March 29, 2021

Re: **3400 Columbia**
3400 Columbia Drive NE
Traffic Circulation Layout
Architect's Stamp 03-14-2021 (G16-D139A)

Based upon the information provided in your submittal received 03-29-2021, the above referenced plan cannot be approved for Building Permit until the following comments are addressed:

REFUSE ENCLOSURE

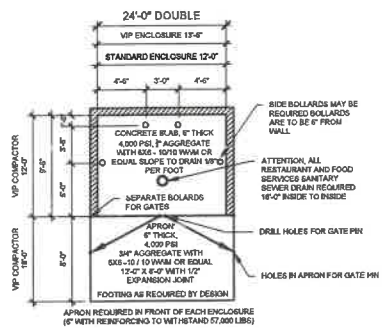
23. Provide a copy of refuse approval.
24. It is not apparent what type of pavement surface is exostonh. A hard driving surface will be required as part of this proposed project for parking area and drive aisles.

BICYCLE CORRAL

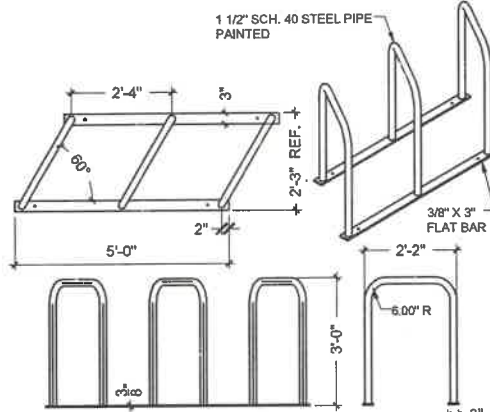
14. All bicycle racks shall be designed according to the following guidelines(If applicable:
 - a. The rack shall be a minimum 30 inches tall and 18 inches wide.

- b. The bicycle frame shall be supported horizontally at two or more places. Comb/toaster racks are not allowed.
 - c. The rack shall be designed to support the bicycle in an upright position. See the IDO for additional information.

- d. The rack allows varying bicycle frame sizes and styles to be attached.
 - e. The user is not required to lift the bicycle onto the bicycle rack.
 - f. Each bicycle parking space is accessible without moving another bicycle.

15. Bicycle racks shall be sturdy and anchored to a concrete pad.
16. A 1-foot clear zone around the bicycle parking stall shall be provided.
17. Bicycle parking spaces shall be at least 6 feet long and 2 feet wide.

HC SIGN

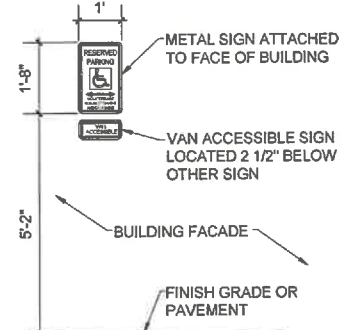
11. ADA handicap parking **sign (ALL) post height** need to follow MUTCD and ADA guidelines.
12. **ADA ramp Status** : Do you need ADA curb ramp from accessible aisle to building? If so provide a detail.

TCL PLAN

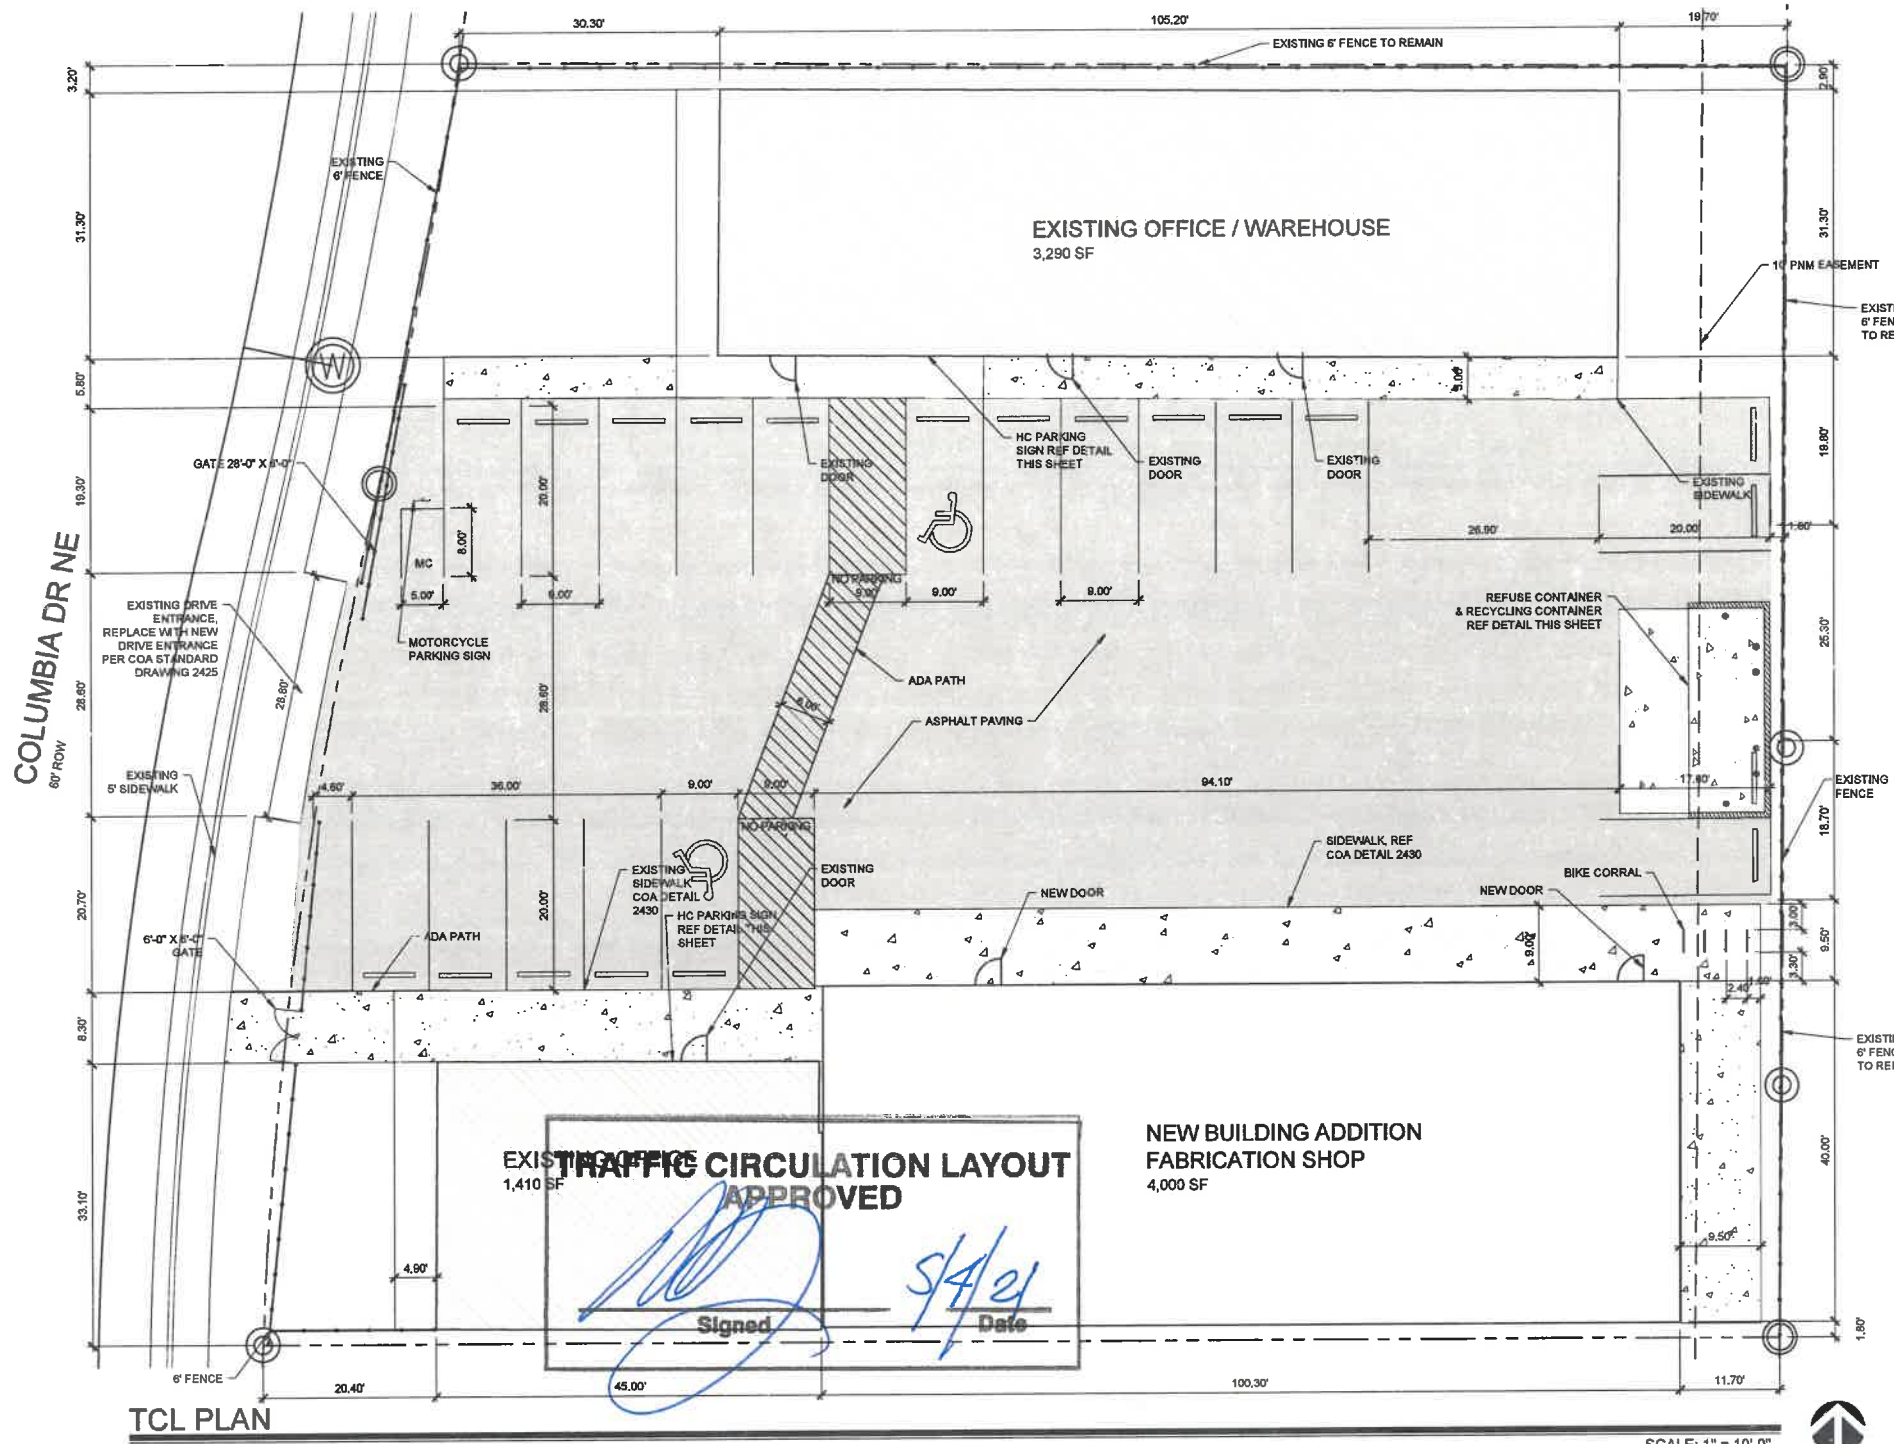
1. Please show a vicinity map showing the location of the development in relation to streets and well known landmarks.
2. List the number of parking spaces required by the IDO as well as the **proposed number of vehicle** parking spaces including **bicycle** and **motorcycle parking** and discuss with Zoning. All required parking spaces requirements will need to be provided and shown on Site Plan.

3. **Driveway Entrance:** Is existing drivepad current ADA accessible and update ADA design? Address this concern.
4. Proposed fence and gate: Provide height and widths on all gates.

5. **Fire Dept.:** Has Fire department reviewed site for vehicular access?
6. Provide details on all proposed parking lot, curb&gutter, and sidewalk infrastructure.

7. Please identify all existing buildings, doors, structures, sidewalks, curbs, drive pads, wall and anything that influences the parking and circulation on the site.

8. Identify all existing access easements and rights of way width dimensions.
9. Identify the **right of way width**, medians, curb cuts, and **street widths** on Columbia

10. The ADA access aisles shall have the words **"NO PARKING"** in capital letters, each of which shall be at least one foot high and at least two inches wide, placed at the rear of the parking space so as to be close to where an adjacent vehicle's rear tire would be placed. (66-1-4.1.B NMSA 1978)

13. Motorcycle parking spaces: **Label pavement MC.**

18. Per the IDO, a **6 ft. wide ADA accessible pedestrian pathway** is required from the public sidewalk to the building entrances. **Please clearly show this pathway and provide details.**

19. Per DPM, a 6 ft. wide ADA accessible pedestrian pathway is required from the ADA parking stall access aisles to the building entrances. **Please clearly show this pathway and provide details.**

20. **Public sidewalk Status?** All sidewalks along streets should be placed at the property line. If existing provide width.
21. **On Site:** provide proposed sidewalk widths

22. Curbing should be installed to delineate landscape, parking, and pedestrian ways and identify points of access. Please call out detail and location of barrier curb.

25. Please provide a sight distance exhibit
26. Show the clear sight triangle and add the following note to the plan: "Landscaping and signage will not interfere with clear sight requirements. Therefore, signs, walls, trees, and shrubbery between 3 and 8 feet tall (as measured from the gutter pan) will not be acceptable in the clear sight triangle.
